# KITTITAS COUNTY

## DEPARTMENT OF PUBLIC WORKS

### MEMORANDUM

TO: Community Development Services  
FROM: Public Works Planning Review Team  
DATE: December 30, 2020  
SUBJECT: Cruth CU-20-00004

Sheet Title  
**SITE PLAN**

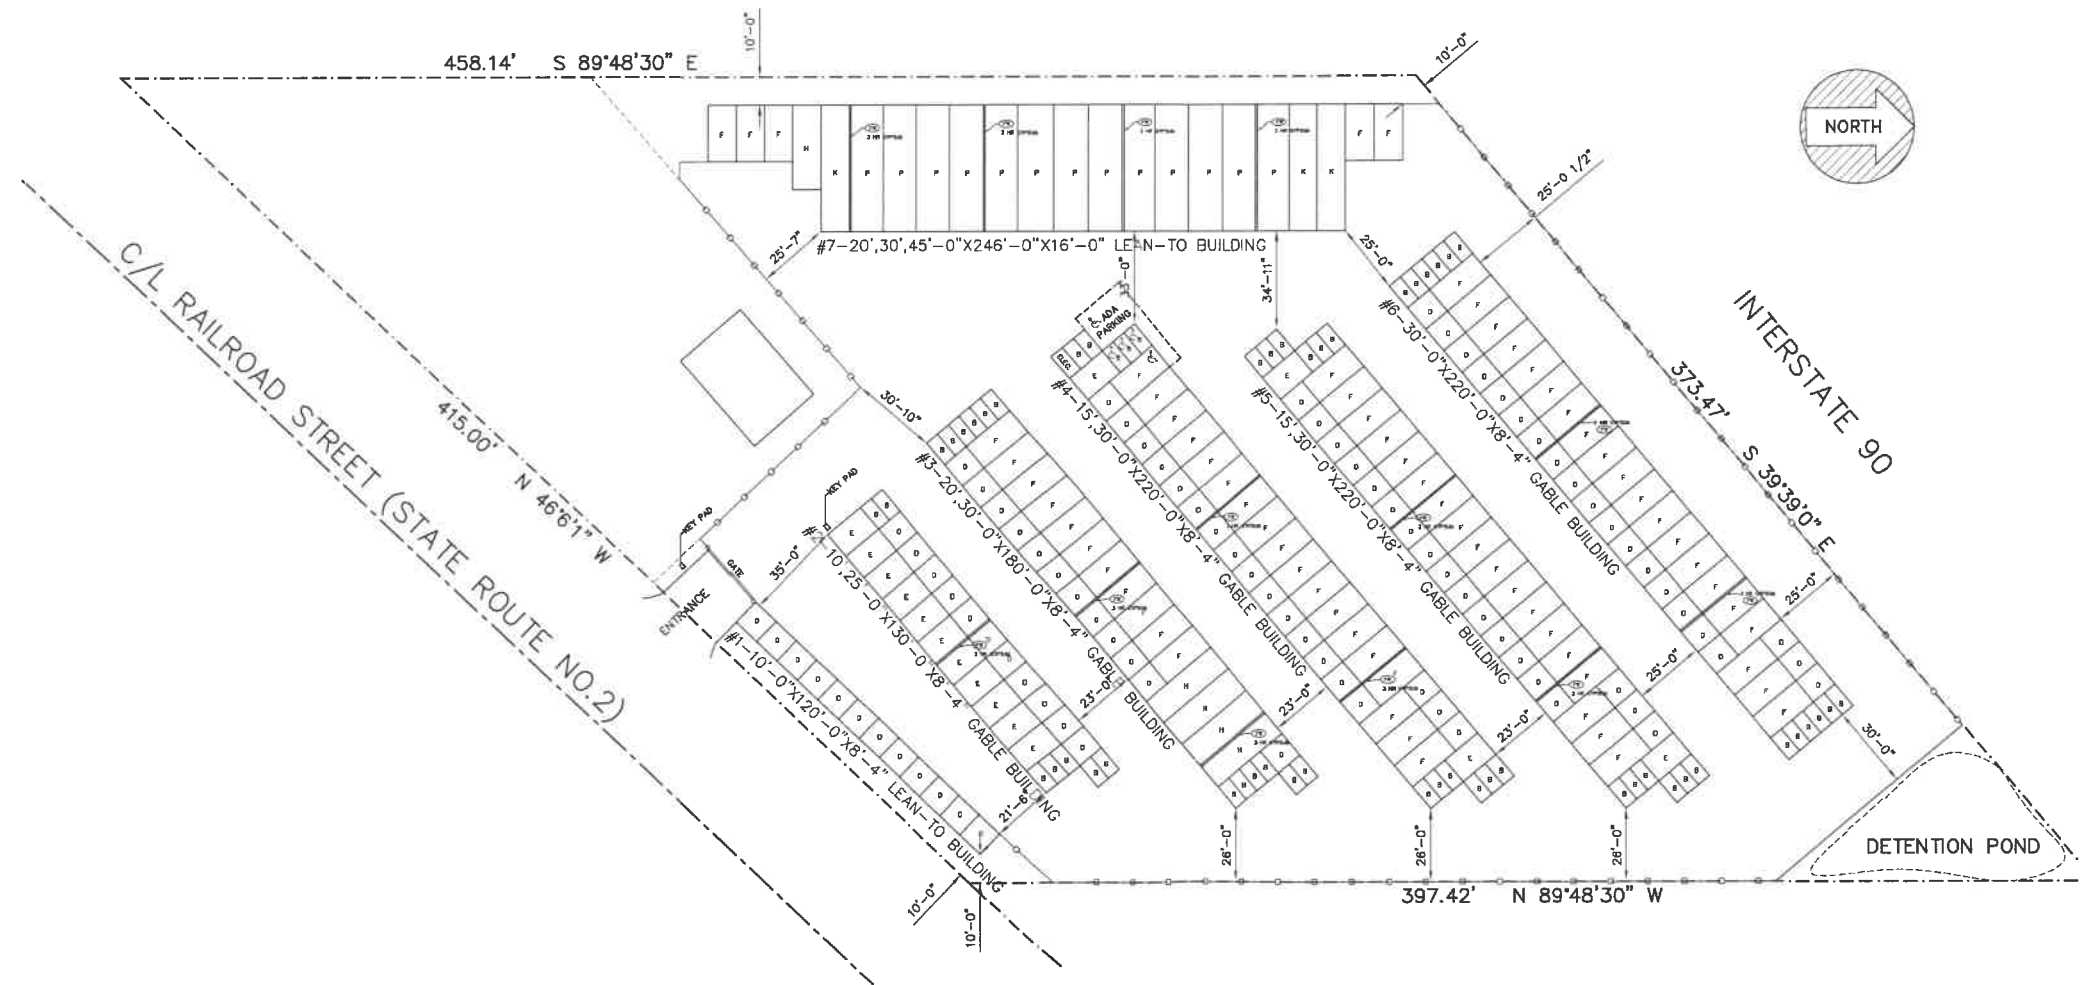
- A. Access: The commercial access will require a paved apron constructed to Kittitas County Private Road Standards. Please contact Public Works for design requirements and questions.

- C. Stormwater Plan: Engineered stormwater plans are required if the project generates an impervious surface exceeding 5000 square feet. The stormwater system will comply with the Stormwater Management Manual for Eastern Washington (SWMMEW). Please submit the stormwater plans to Public Works for review.

1. A stormwater report, as outlined by the Eastern Washington Stormwater Manual, to Public Works for review.
2. A more detailed plan set including topographic contours through the project area, a cross section of the drainage pond, and labels for any drainage structures (catch basins and pipes) which drain to the drainage pond.
